**Office of
Environment
& Heritage**

**Re: OEH comments on the Environmental Assessment for McWilliams Winery
Expansion Project MP 09-0177**

Figure 5: Pipeline route

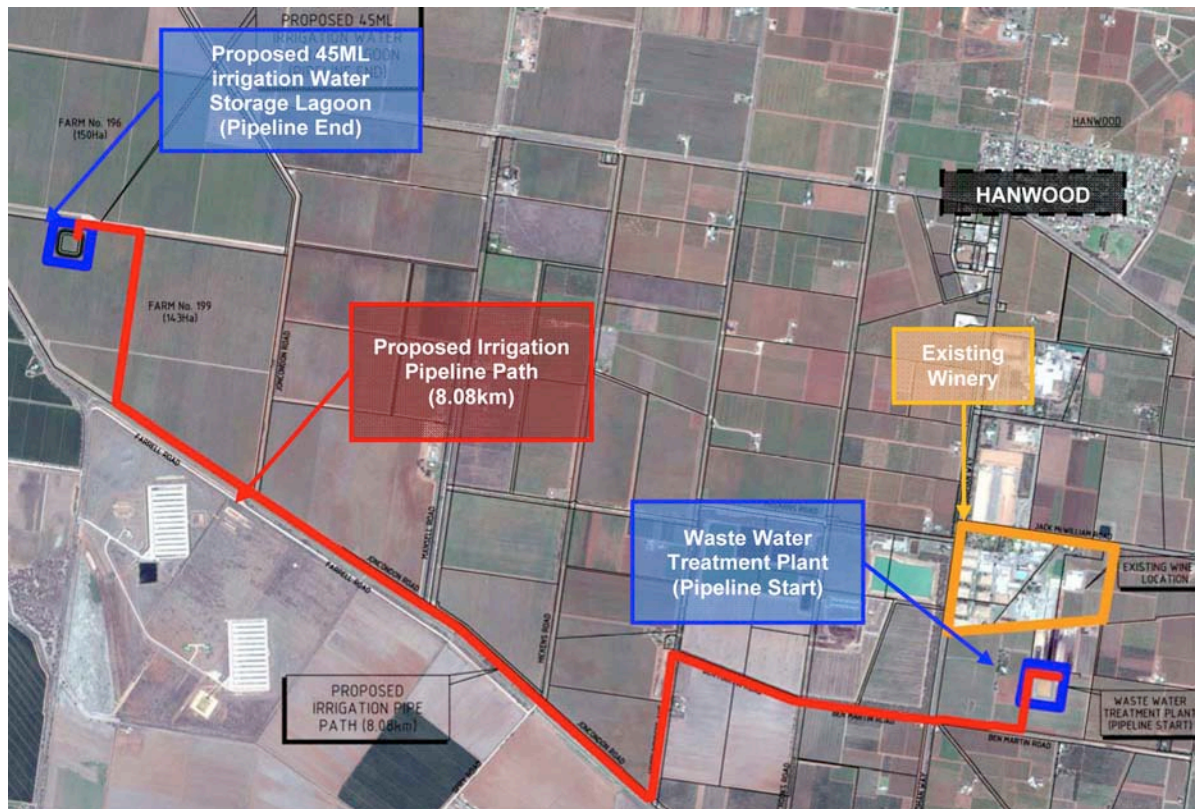
- An Environmental Management Plan (EMP) must be prepared prior to construction that includes on details methods that will minimise impacts on biodiversity during construction. This will include information on the final pipeline route, protocols for clearing to minimise disturbance and impacts and native fauna and actions to identify potential threatened species including Endangered Ecological Communities.

- The pipeline route should avoid area of native vegetation as much as possible, including aligning with existing table drains and as far from existing vegetation as possible.

**Figure 4: Locations of Aboriginal sites recorded during the current study (Base map source: Department of Lands).**

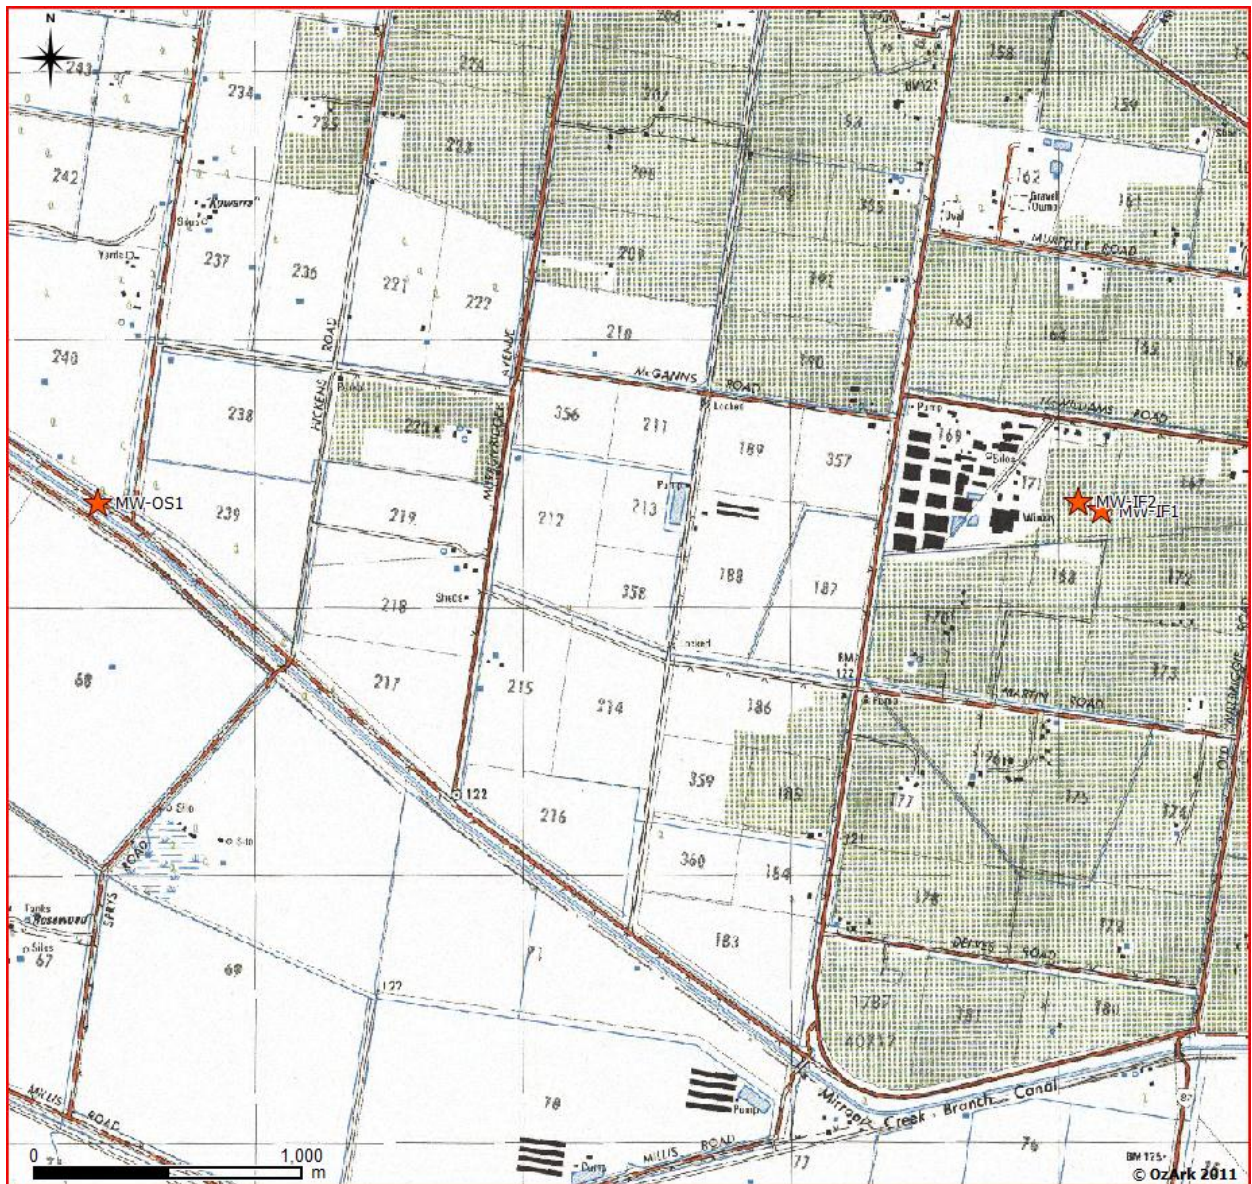
OEH recommends that the SoC under the heading of **Heritage** be modified, as follows, to clearly articulate the recommended actions that will be implemented:

- If possible, locate and collect isolated artefacts MW-IF1 and MW-IF2, and relocate the artefacts nearby out of harms way.
- Locate and collect artefact scatter MW-OS1 prior to trenching and relocate the artefacts nearby out of harms way. Monitoring, by the Aboriginal community, will occur along a ca. 200 m section of the pipeline in the vicinity of MW-OS1 to collect and relocate objects should they be present.
- Management of any collected artefacts will occur in consultation with the Aboriginal community.
- Staff and contractors will undergo cultural heritage inductions alerting them to the location of recorded cultural heritage sites within the study area.
- Should any previously unidentified Aboriginal objects be uncovered during construction, work in that area will cease and the OEH Regional Archaeologist and local Aboriginal community will be contacted to discuss how to proceed.
